From: Maria Tomalova
Sent: 08 September 2020 18:10
To: Planning.Responses
Subject: FW: AW/222/20/PD - 16a Rose Green Road, Aldwick, PO21 3ET

From: Kate Giddings <kate.giddings@arun.gov.uk>
Sent: 08 September 2020 13:54
To: Maria Tomalova <Maria.Tomalova@arun.gov.uk>
Cc: Planning.Responses <Planning.Responses@arun.gov.uk>
Subject: AW/222/20/PD - 16a Rose Green Road, Aldwick, PO21 3ET

16/A ROSE GREEN ROAD		
BOGNOR REGIS PO213ET		
FIRST FLOOR	SCALE 1:50	
DRAWING REF : 001	DATE	24/8/20

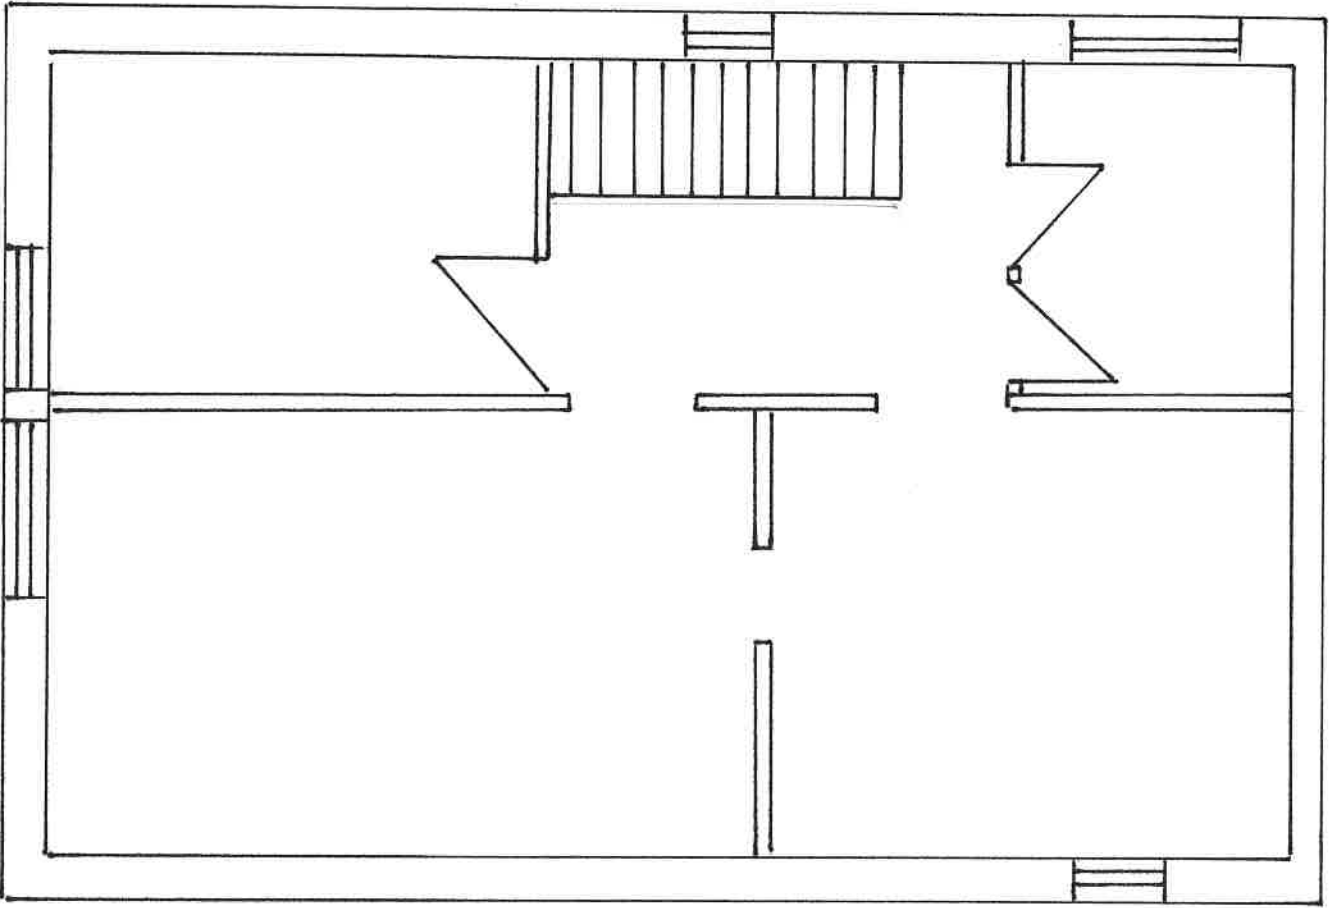
- The sound insulation of the floor/ceiling between the ground and first floor shall achieve a minimum airborne sound insulation value of 50 dB ($D_{nT,w} + C_{tr}$). Before the residential unit is

occupied, a test shall be undertaken by a competent acoustician and submitted to the Local Planning Authority to demonstrate compliance with this level. **Reason:** To protect the amenity of local residents in accordance with Policy QE SP1 of the Adopted Arun Local Plan 2011 – 2031
